10 September 2025

The Manager
Major Projects NSW
Department of Planning, Housing and Infrastructure

**Re: Submission of Objection to State Significant Development Application
SSD-82709458 at 19-25 Balfour Street, Lindfield, NSW 2070**

1 **OVERSHADOWING - 9AM JUNE 21 (EXISTING)**
1 : 1000

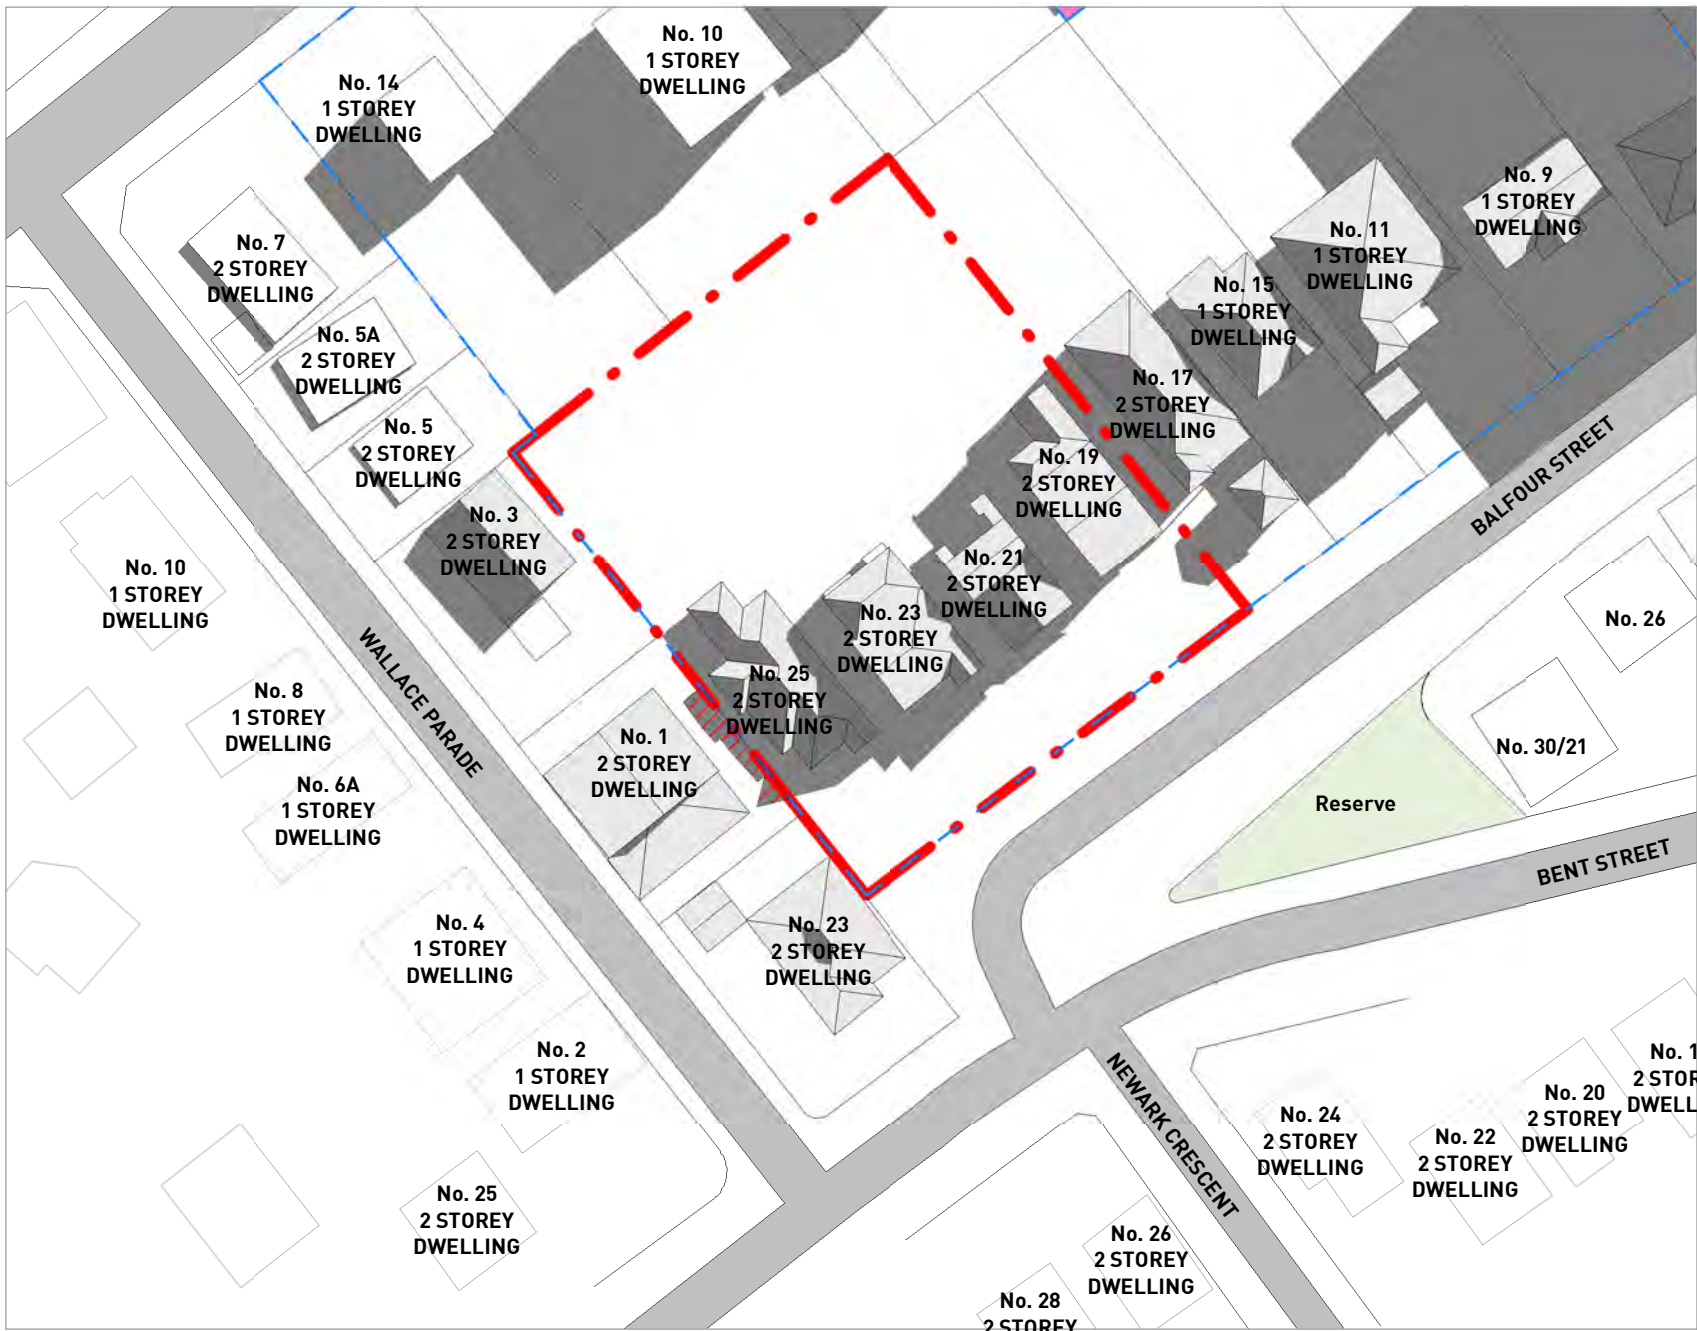
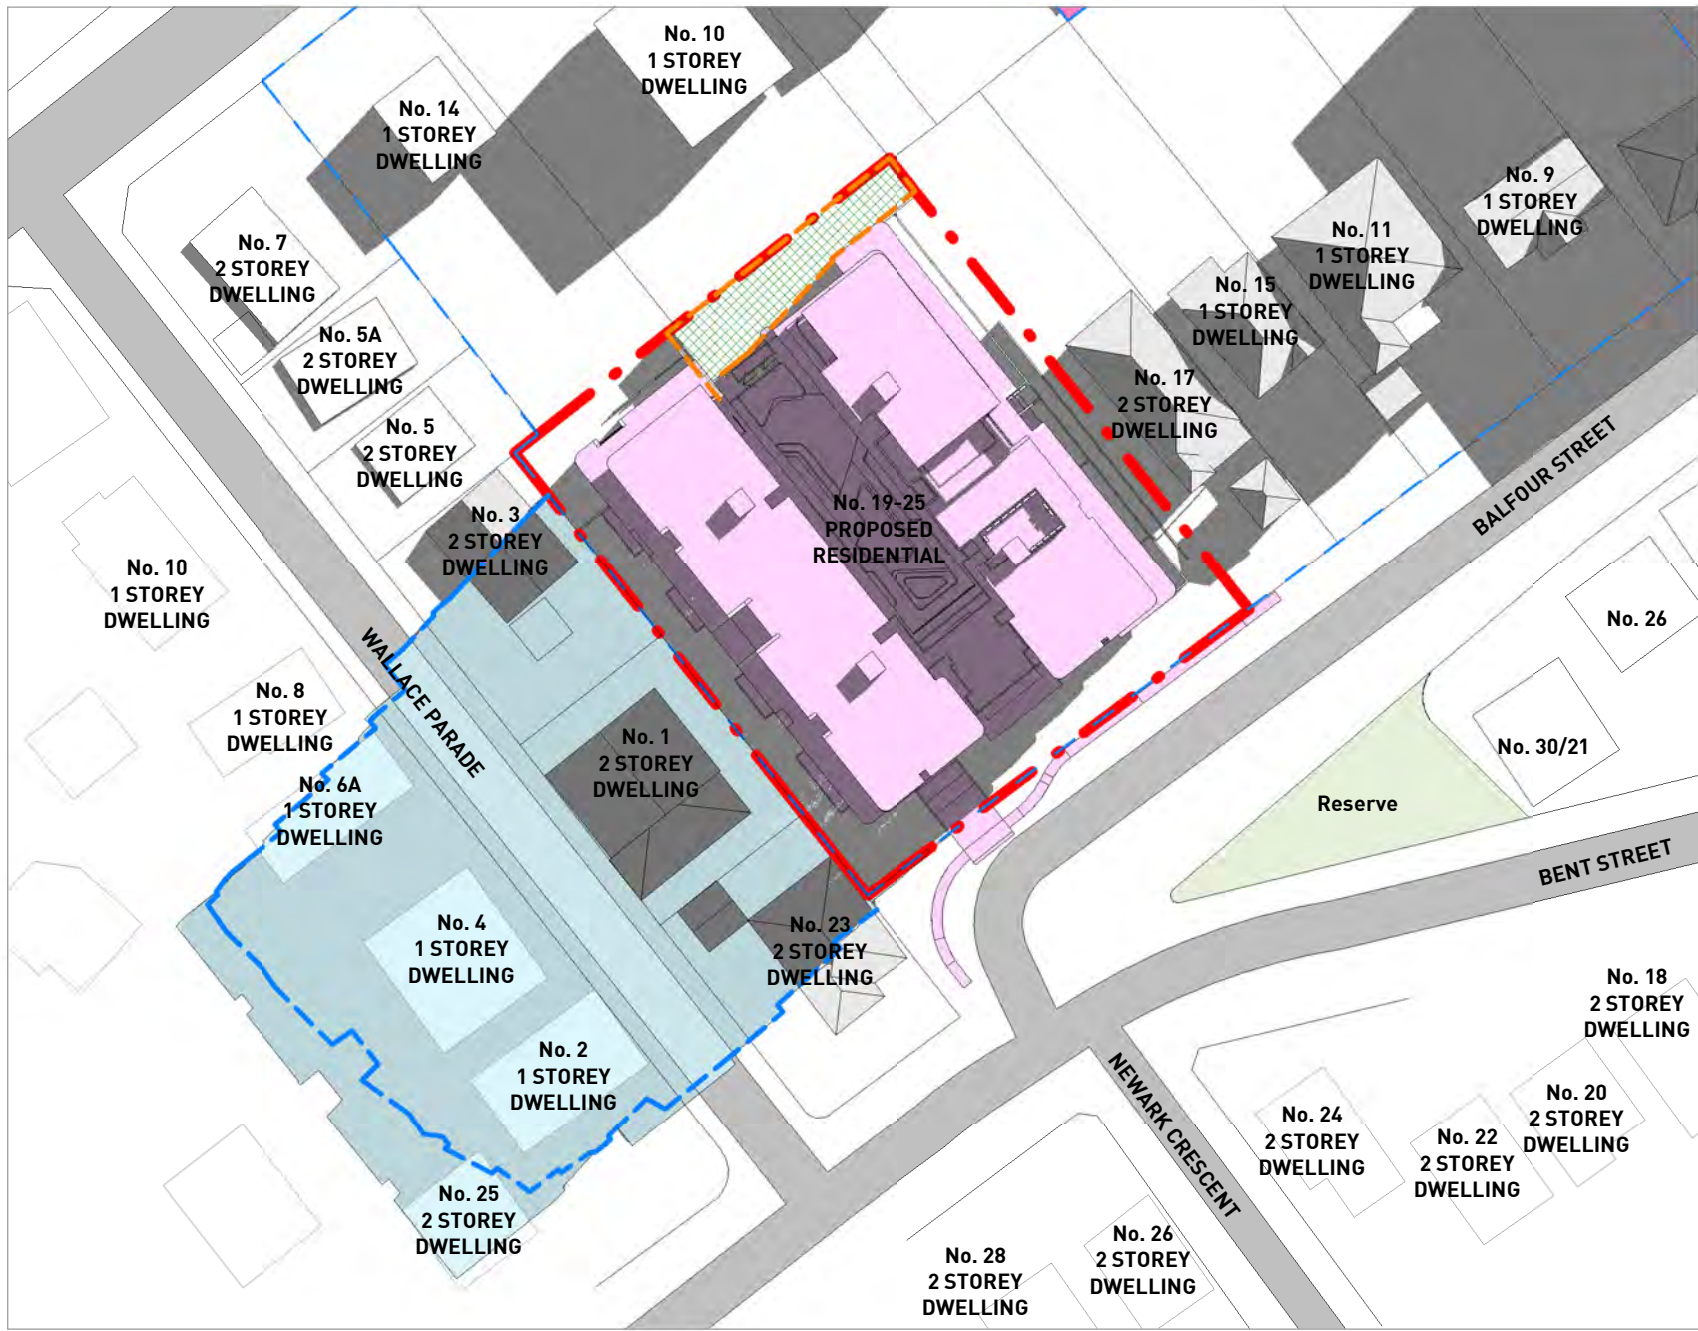
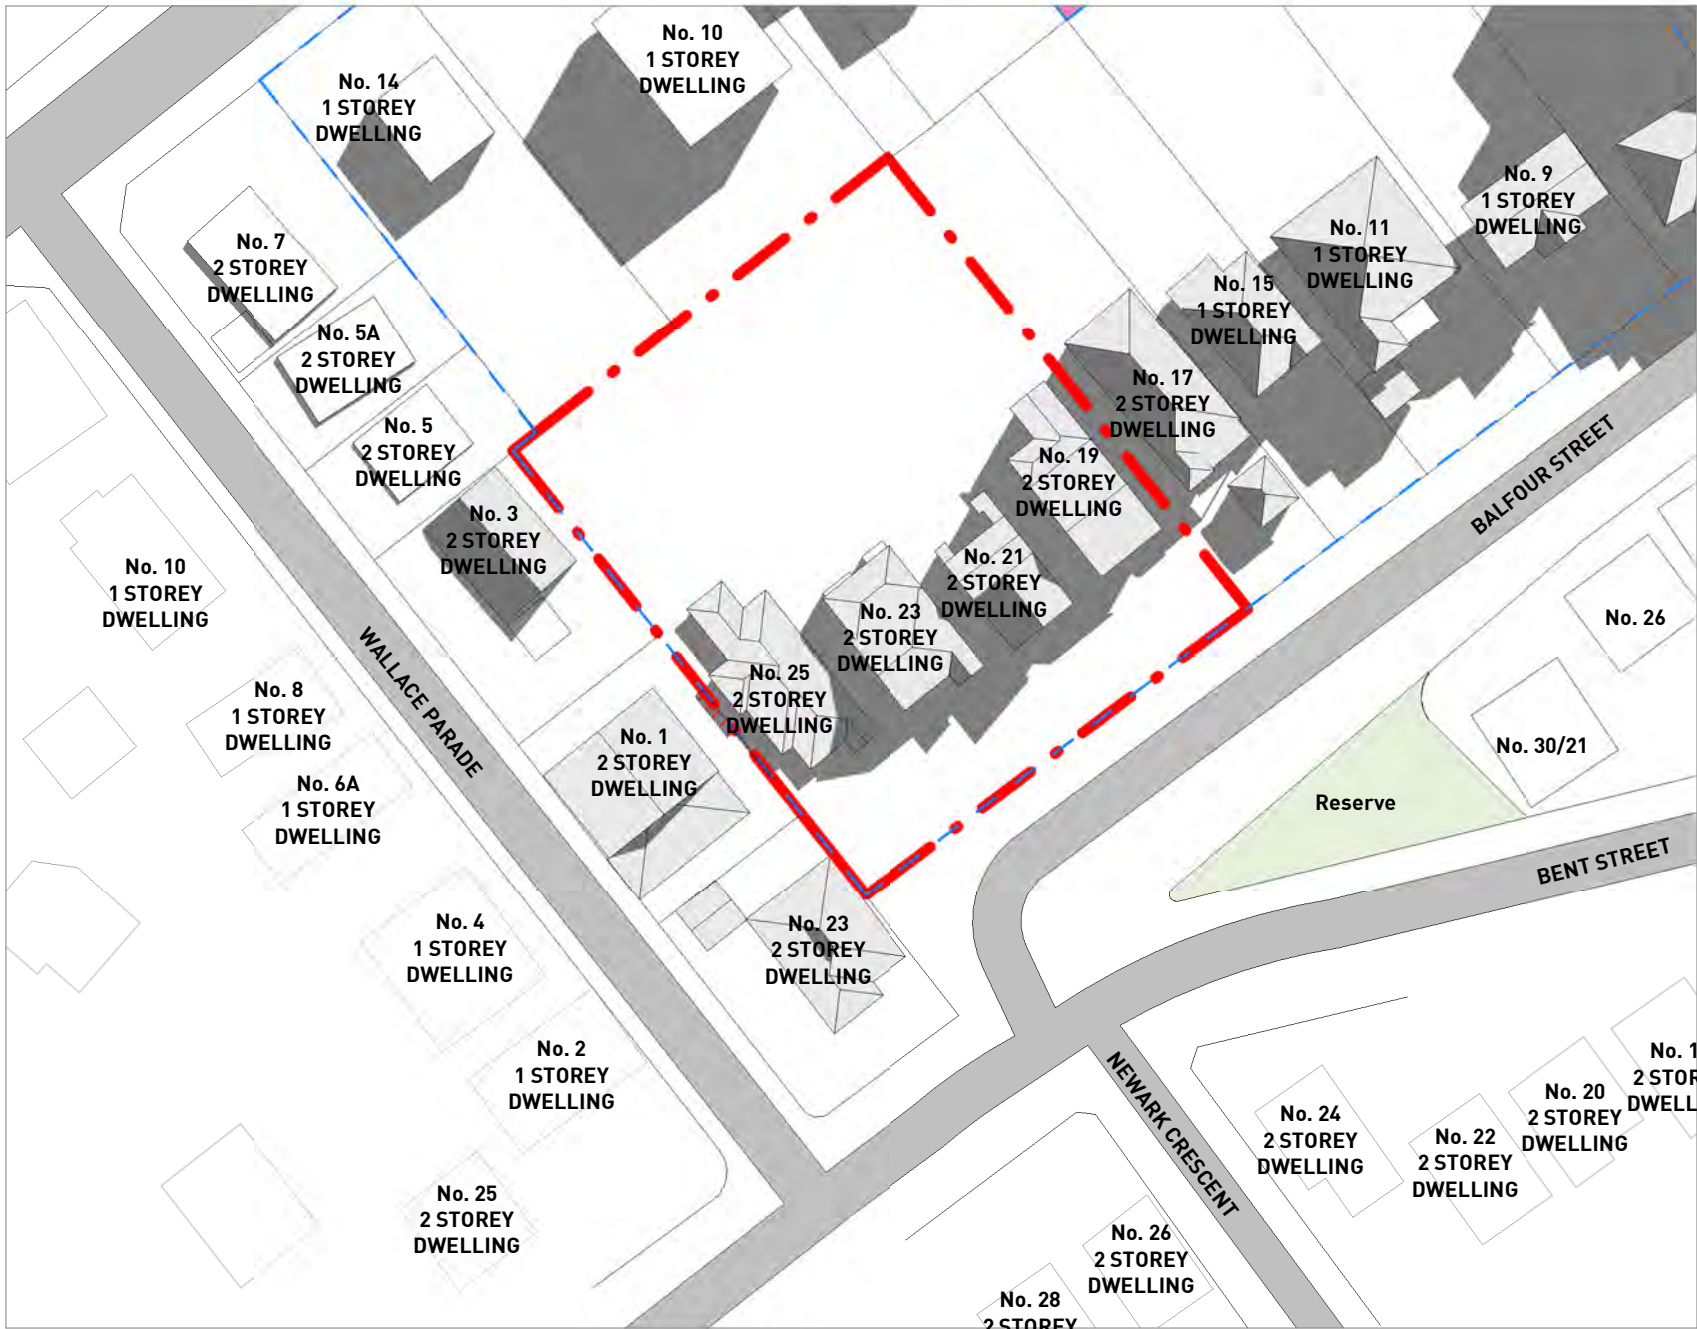
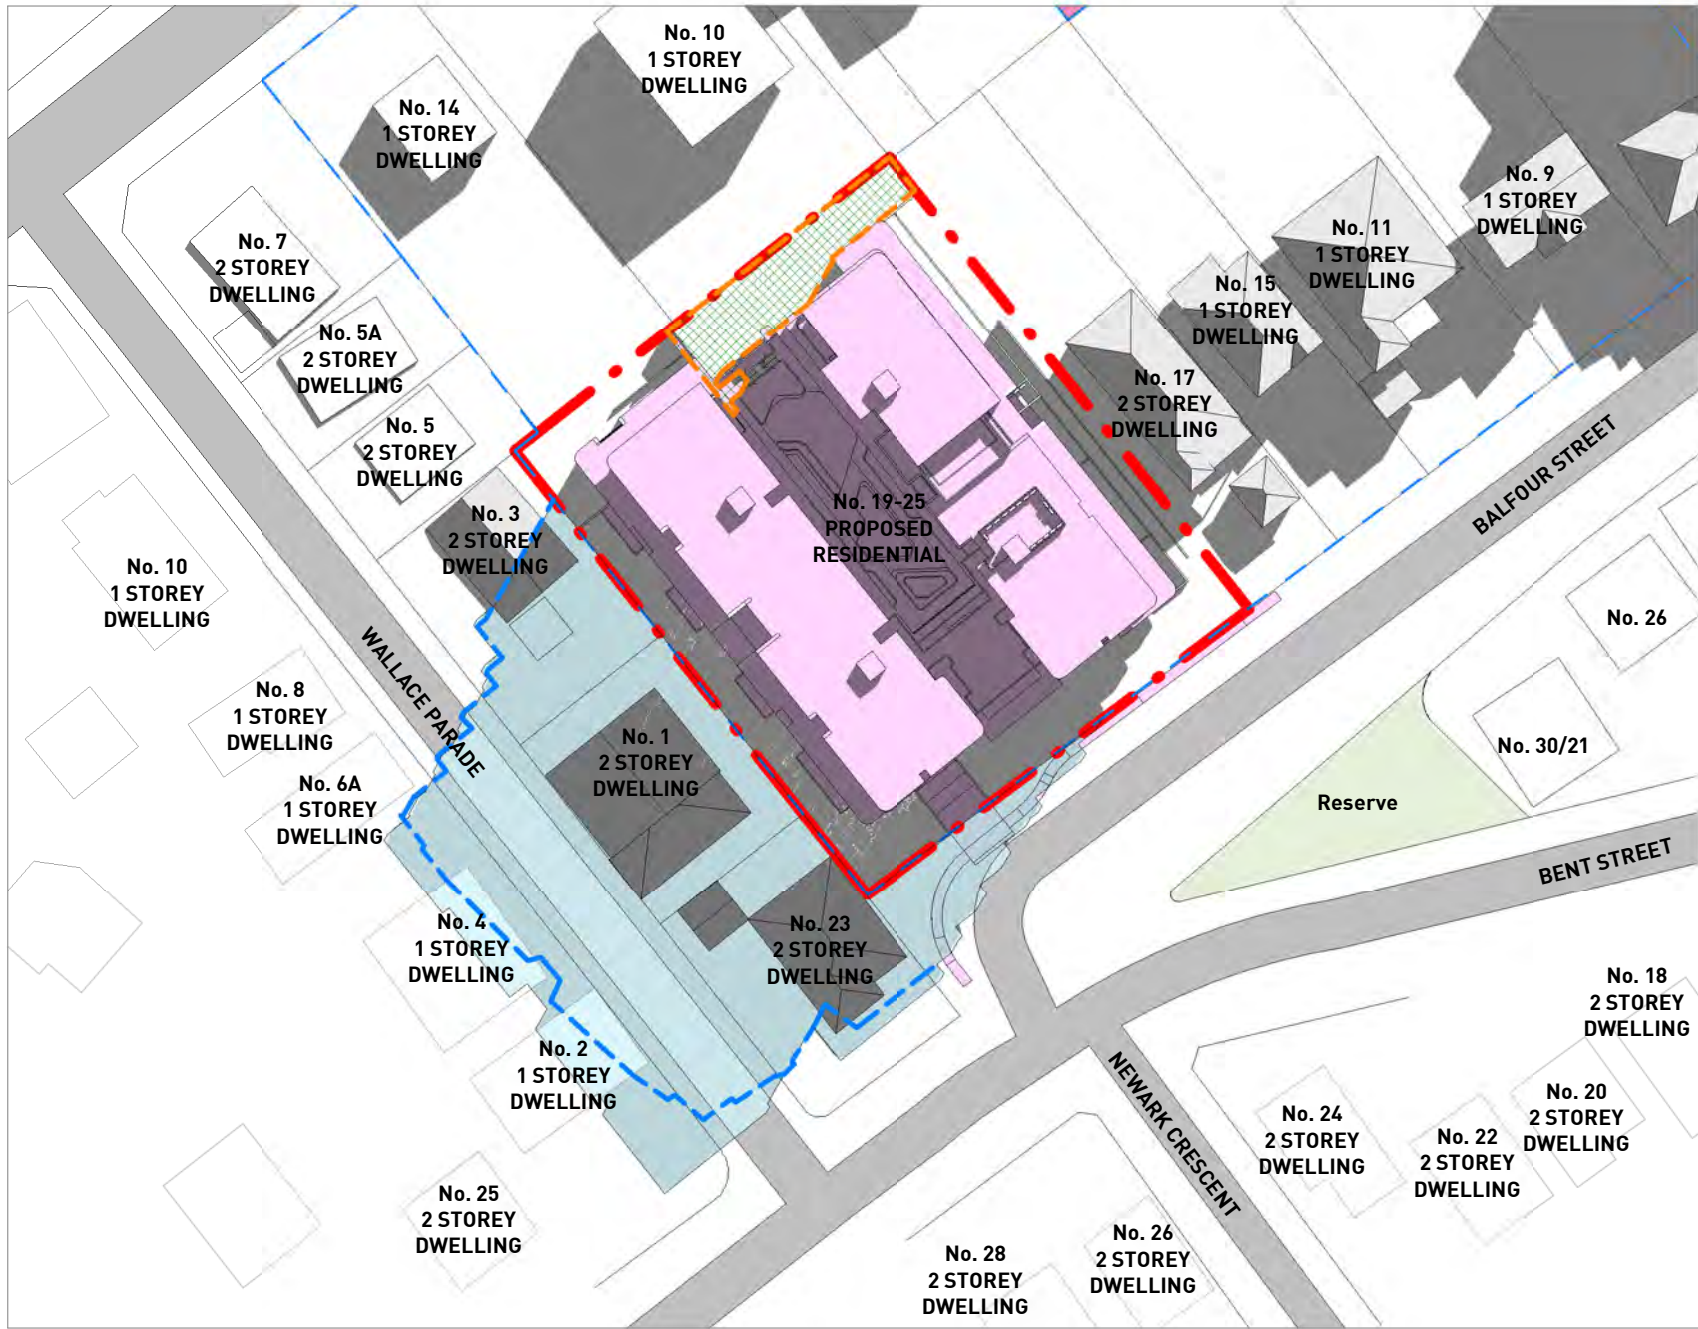
The morning shadow diagrams that would affect 14 Highfield Road have not been drawn at all. It is clear that the morning sun will not reach my yard, especially during
